15 August 2017

**STATE SIGNIFICANT DEVELOPMENT 3846 – WEST CULBURRA MIXED USE
SUBDIVISION – SUPPLEMENTARY RESPONSE TO SUBMISSIONS**

RMS has reviewed the 'Supplementary Response to Submissions' (SRS) dated July 2017, including the appendixes, and provides the following comments:

Figure 12. The layout of the roundabout

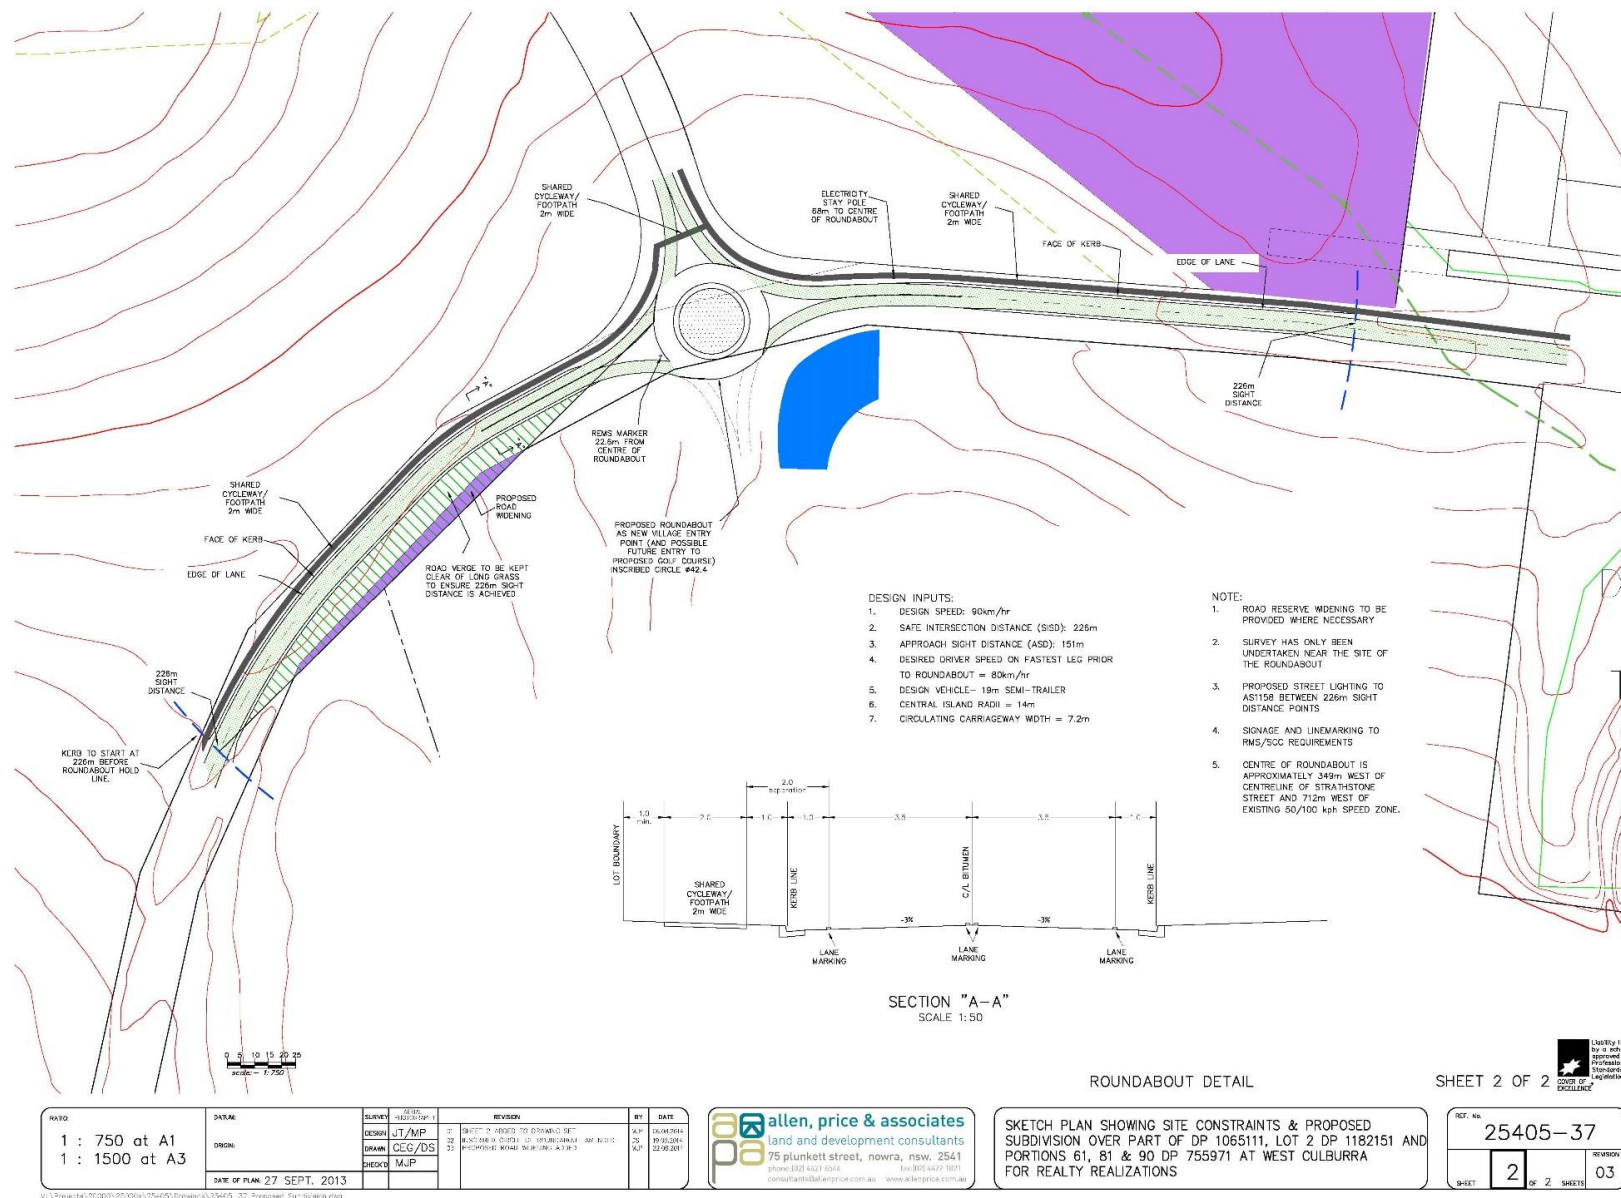
- As previously advised in its letter dated 6 May 2014, RMS has reconsidered its position in relation to a speed reduction and will now support a speed reduction to 80km/h to facilitate the provision of a roundabout that provides a consolidated access to the development. The above is subject to compliance with the following:

- The roundabout must be designed and constructed in accordance with *Austrroads Guide to Road Design*;
 - The roundabout would need to be placed to achieve appropriate sight distances. Given that the roundabout would be located immediately after the transition from the 100km/h speed zone, RMS advises that the design speed for sight distances needs to be 10km/h above the intended posted limit. Assuming a posted speed limit of 80km/h, the sight distance would need to comply with Austrroads standards for a 90km/h speed environment. This includes appropriate sight distance to the layout of the roundabout for both east bound and west bound vehicles. The location of the roundabout and demonstration of compliance with sight distances would need to be based on survey and design;

- The roundabout would need to be supported by a suite of measures on Culburra Road to reinforce the change of environment from a rural environment to an urban environment. This would need to commence on the eastbound approach to the roundabout and continue through the roundabout into the existing township. This could include, but not be limited to street lighting, kerb and gutter, off road paths and landscaping to reinforce the 80kph environment on the urban fringe. These measures would need to be provided for a distance equivalent to safe intersection sight distance. The proponent needs to identify and commit to a suite of measures on Culburra Road prior to determination of the project.

Insufficient details to address the above have been provided as part of the SRS (e.g. plans demonstrating compliance with the above).
